**Consultation Response from KC,
Trees**

**2023/93576 land to the east of Robledo, Beaumont Park Road, Beaumont Park, Huddersfield,
HD4 5JT**

Erection of detached dwelling

Date Responded: 15/02/2024

Appendix 3: Proposed Development Plan

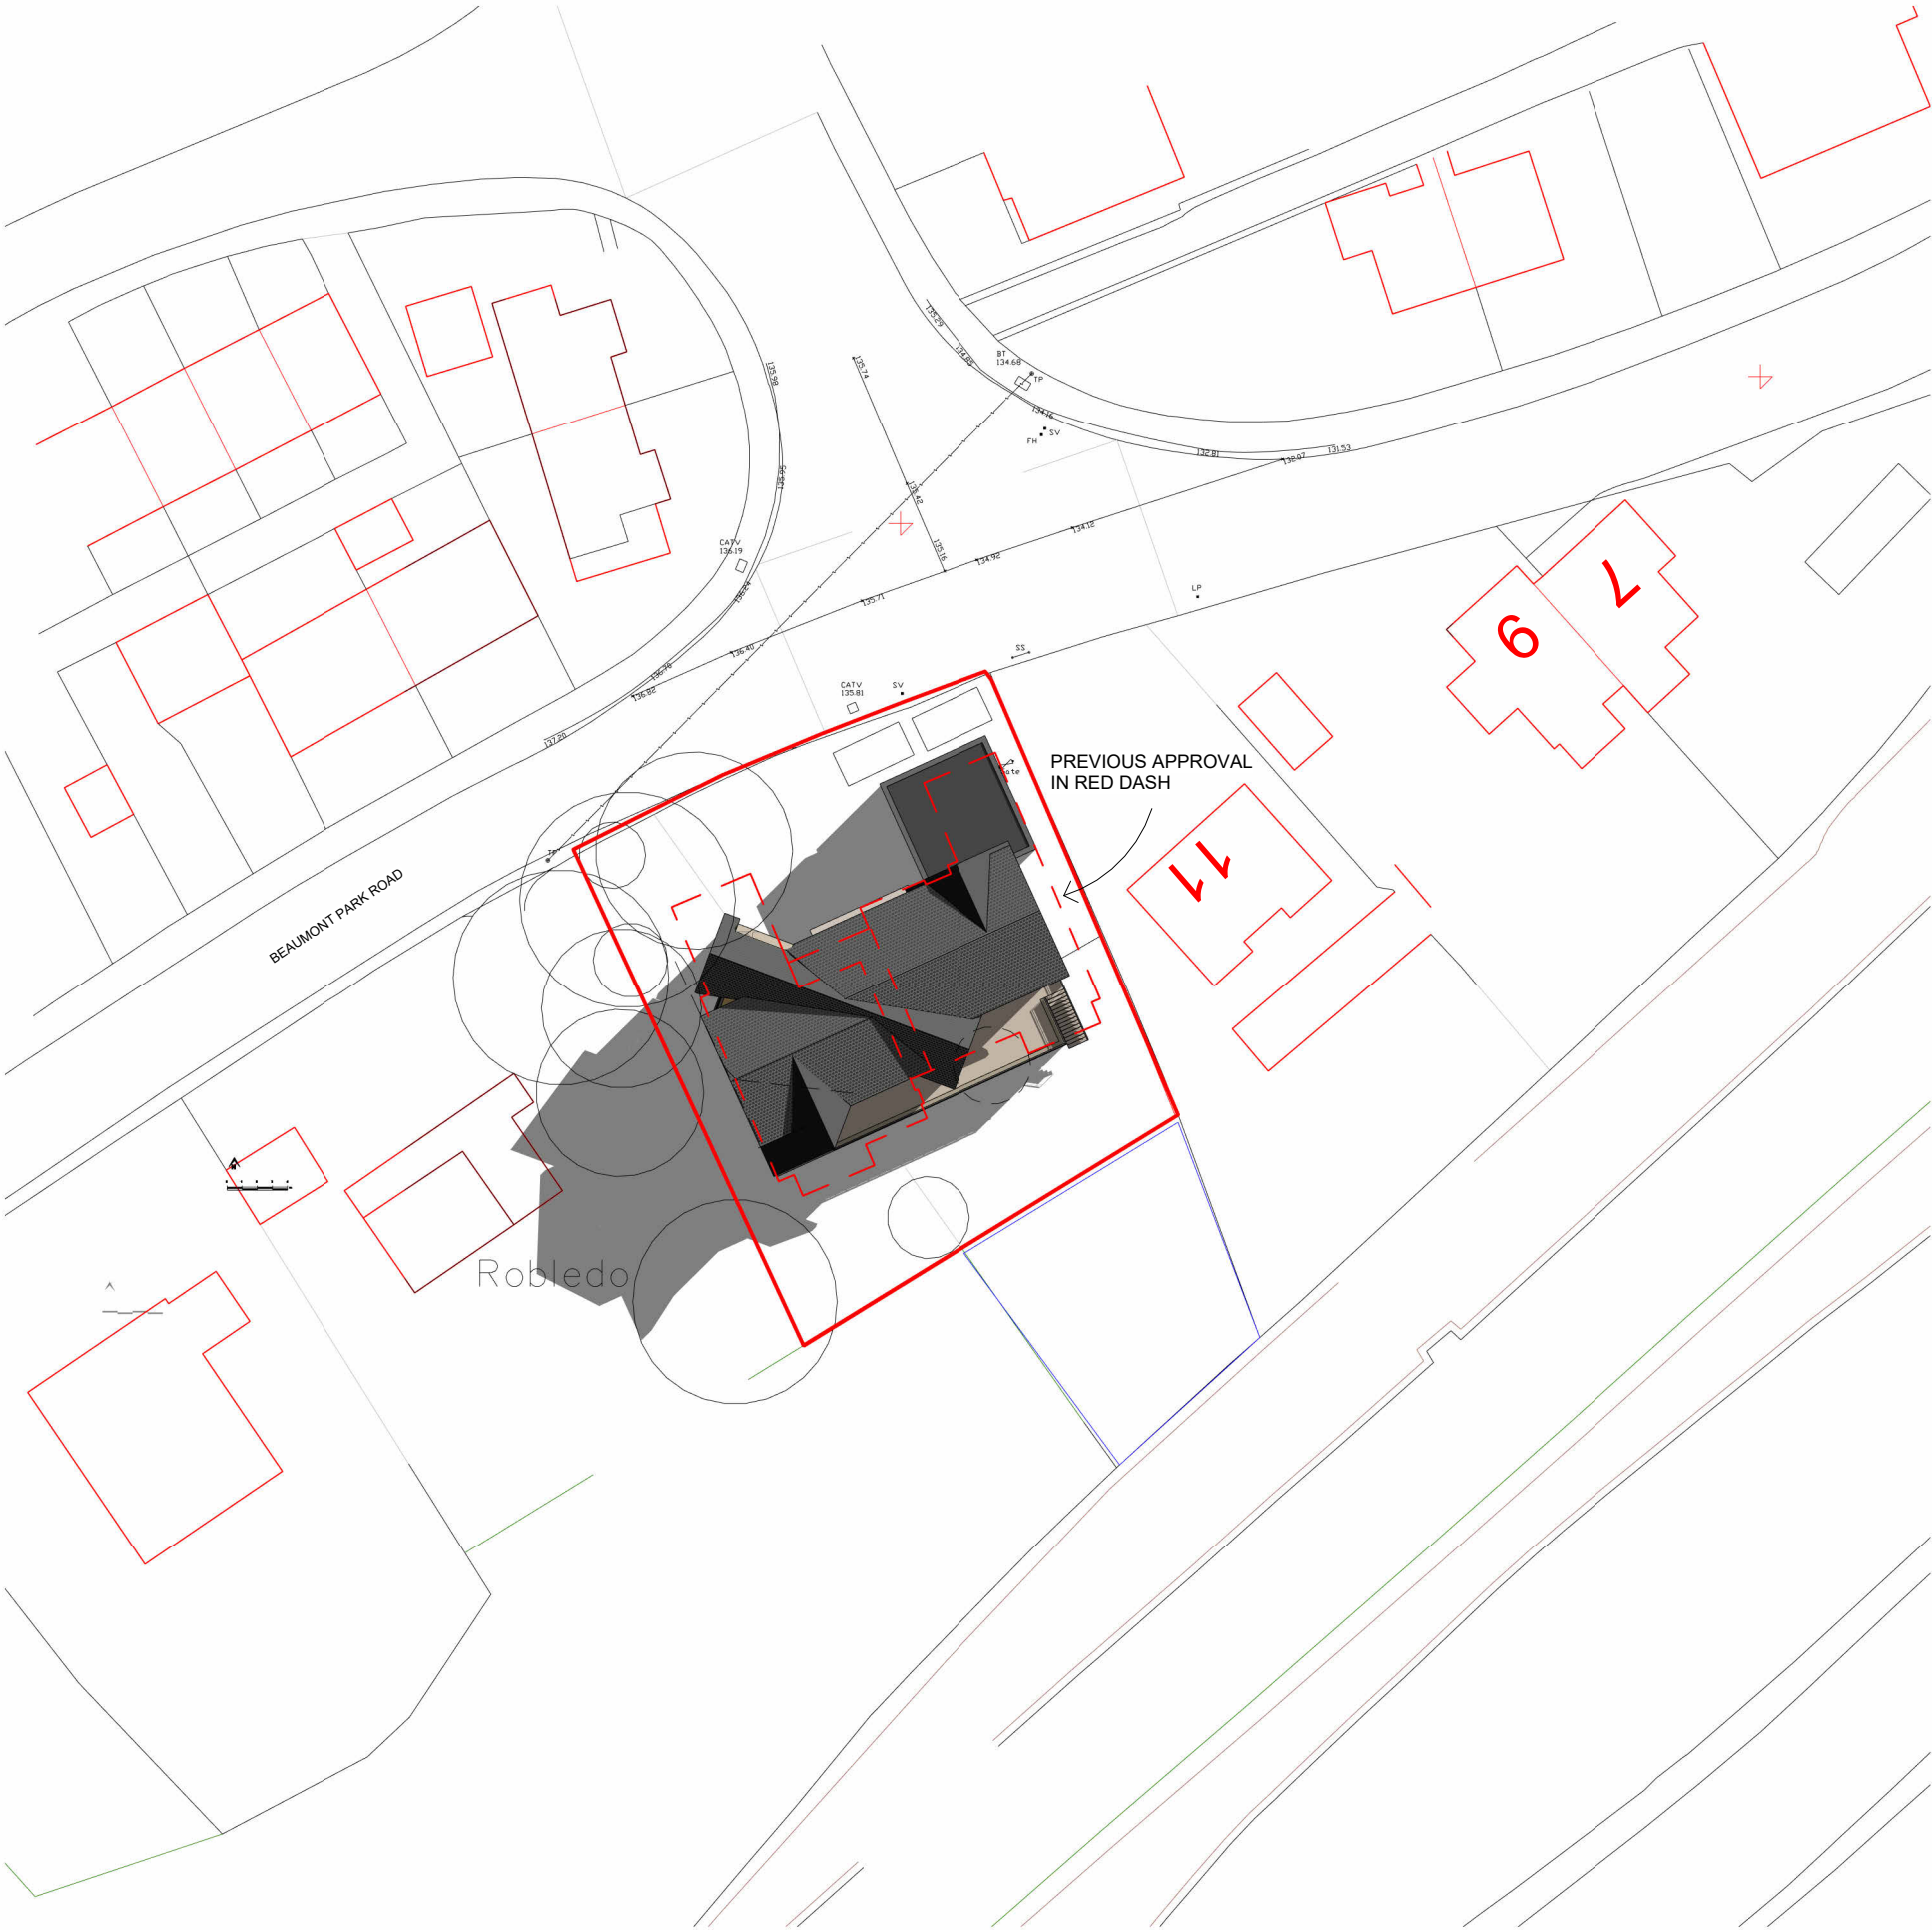
The proposals show the development to be immediately adjacent to the western trees which may cause a number of issues.

Firstly, if the foundations are to be dug within the root protection areas it would be classed as wilful damage to protected tree roots.

Secondly, The habitable rooms to the west of the house would be shaded by the adjacent trees. This could lead to pressure to have tree works performed on the trees to alleviate the shade.

Lastly, due to the close proximity of the construction work there is a risk that the protected trees would be damaged by either machinery or soil compaction from the storage of materials and heavy machinery or footfall. This would also fall under wilful damage.

For the above reasons there would be a holding objection from a trees perspective until an Arboricultural Impact Assessment is provided that shows the full impact the proposals will have on the surrounding trees and following that an Arboricultural Method statement showing the tree protection measures that would need to be taken when working around protected trees.
